Matthew Rosel - Submission Details for Mitza Grocott (object)

Submission for Job: #5878 SSD 5878-2013 Sydney International Convention, Exhibition and Entertainment Centre Precinct - Mixed use Development in the Southern Haymarket Precinct (Concept Proposal)
https://majorprojects.affinitylive.com?action=view_job&id=5878

SSD 5752, Sydney International Convention, Exhibition and Entertainment Precinct – Redevelopment of convention centre, exhibition centre, entertainment facilities and associated public domain works (SSD) is referred to as **PPP**

Sydney International Convention, Exhibition and Entertainment Centre Precinct – Mixed use Development in the Southern Haymarket Precinct (Concept Proposal) (SSD) is referred to as **PDA**

Figure 6: Maximum building envelope of The Haymarket precinct

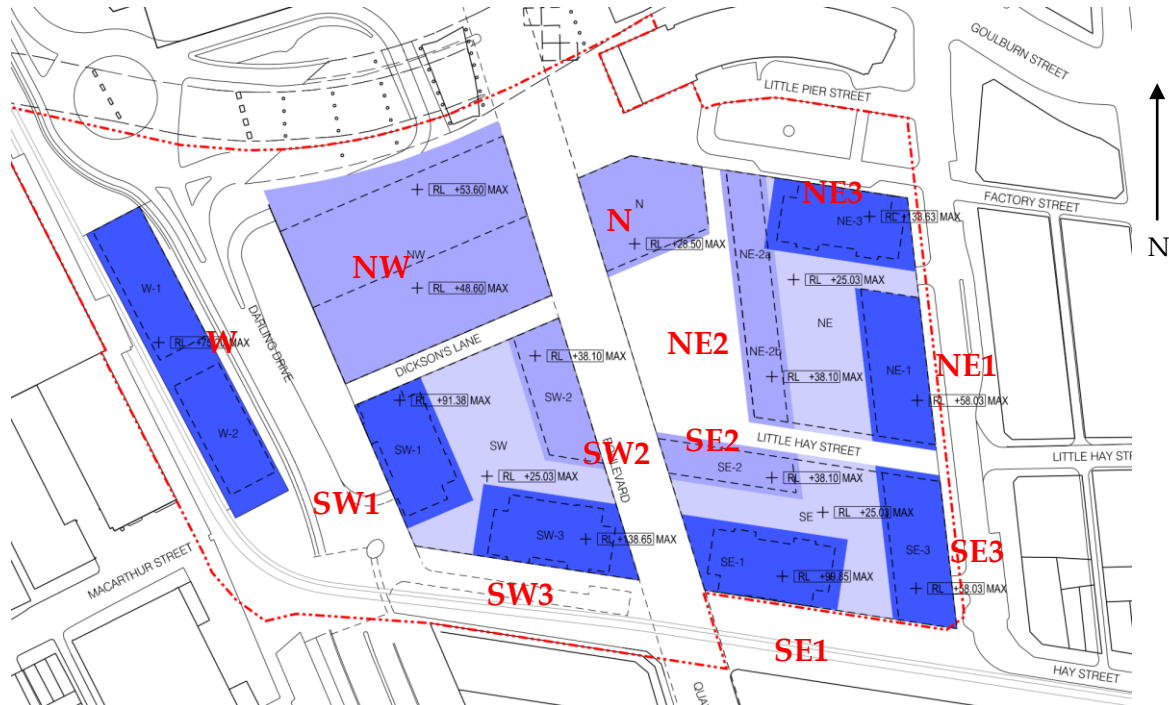
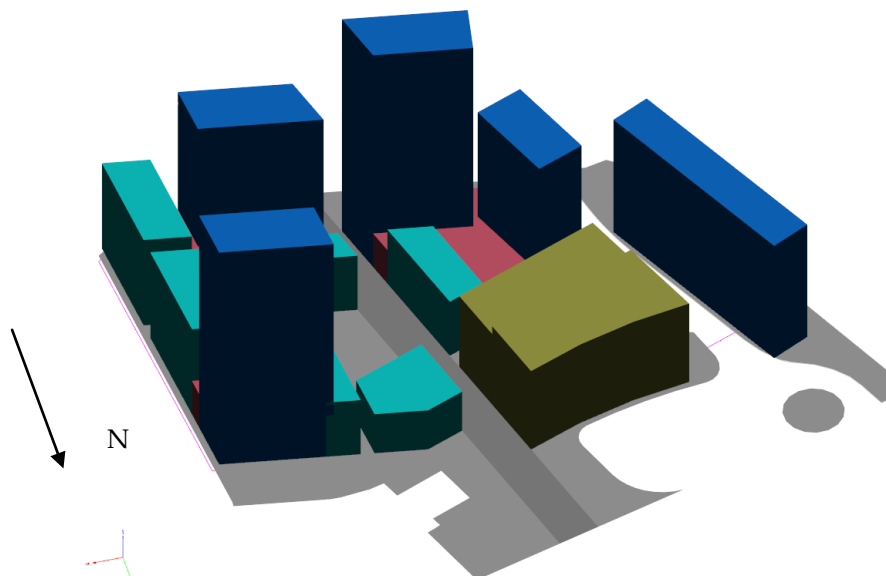
Cermak Peterka Petersen (CPP) also appear reticent in their approval. The report finds that the proposed building envelopes may result in downwash from taller buildings, and that windy conditions could be expected at ground level at the windward corners of the buildings. Channelling wind flow could also be experienced at some locations without appropriate amelioration.

It is not unreasonable to suppose that a strong southerly wind would be channelled between SE1 and SW3, howl up the boulevard and will cause a cyclonic effect in the Haymarket Square.
